WEST SUSSEX COUNTY COUNCIL CONSULTATION

TO:	Arun District Council FAO: Stuart Corbey
FROM:	WSCC - Highways Authority
DATE:	10 April 2019
LOCATION:	Land at Watersmead Business Park Worthing Road Littlehampton BN17 6LS
SUBJECT:	LU/59/19/PL Installation of 5 No. 'vehicle-to-ground' lifts, HVAC plant units, a canopy cover over the associated service yard area for a temporary period of five years, installation of 3 No. level access doors, minor alterations to internal access road including widening works, creation of a new spur, provision of a pedestrian footbridge & associated lighting & drainage infrastructure provision. Amendment received.
DATE OF SITE VISIT:	N/A
RECOMMENDATION:	Advice
S106 CONTRIBUTION TOTAL:	N/A

Proposed Tree Planting Works

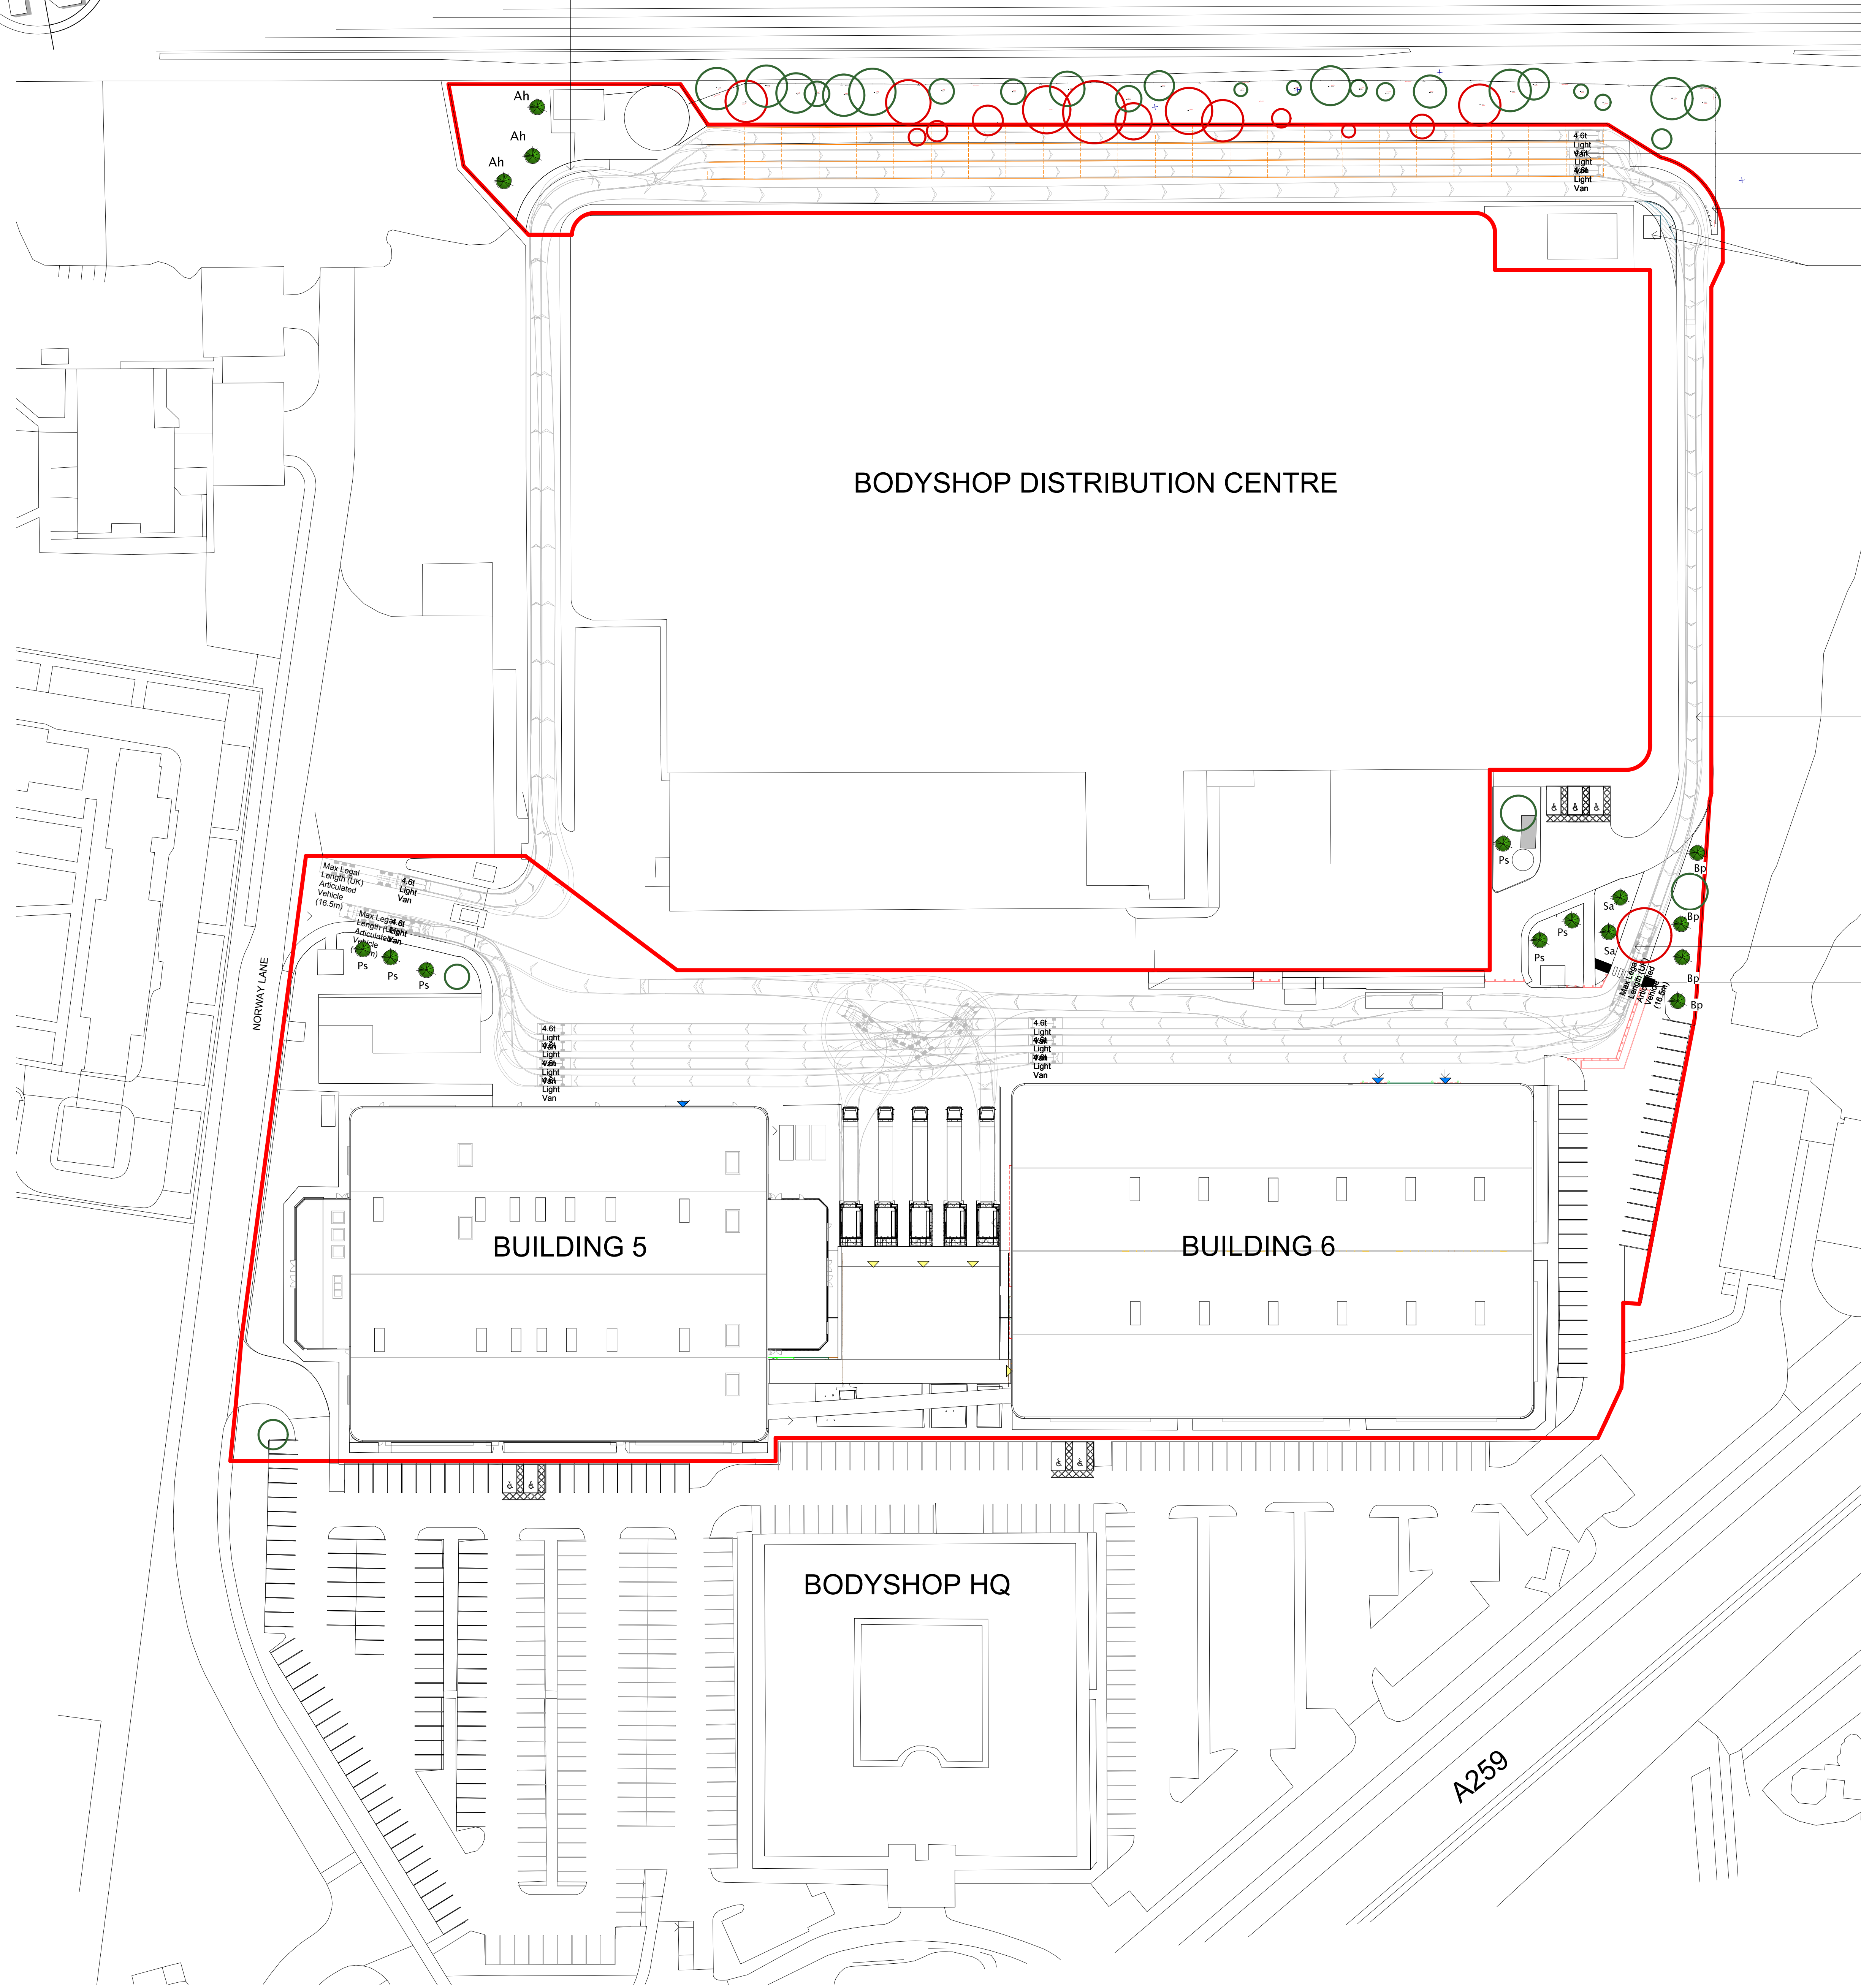
The LHA provides this response following submission of a revised site plan demonstrating a widened kerb line to the northeast of the site. The LHA previously advised that the applicant may wish to consider widening kerb lines at the north western and north eastern corners of the site to facilitate HGV manoeuvrability. The revised plan appears to provide additional space to enable HGVs to manoeuvre the northeastern corner of the site. No revisions to the northwestern corner have been made, this is likely due to site constraints. As mentioned previously, if possible, the applicant may wish to consider widening the kerb line to improve manoeuvrability in the northwestern corner of the site, however, this is not anticipated to result in a highway safety concern.
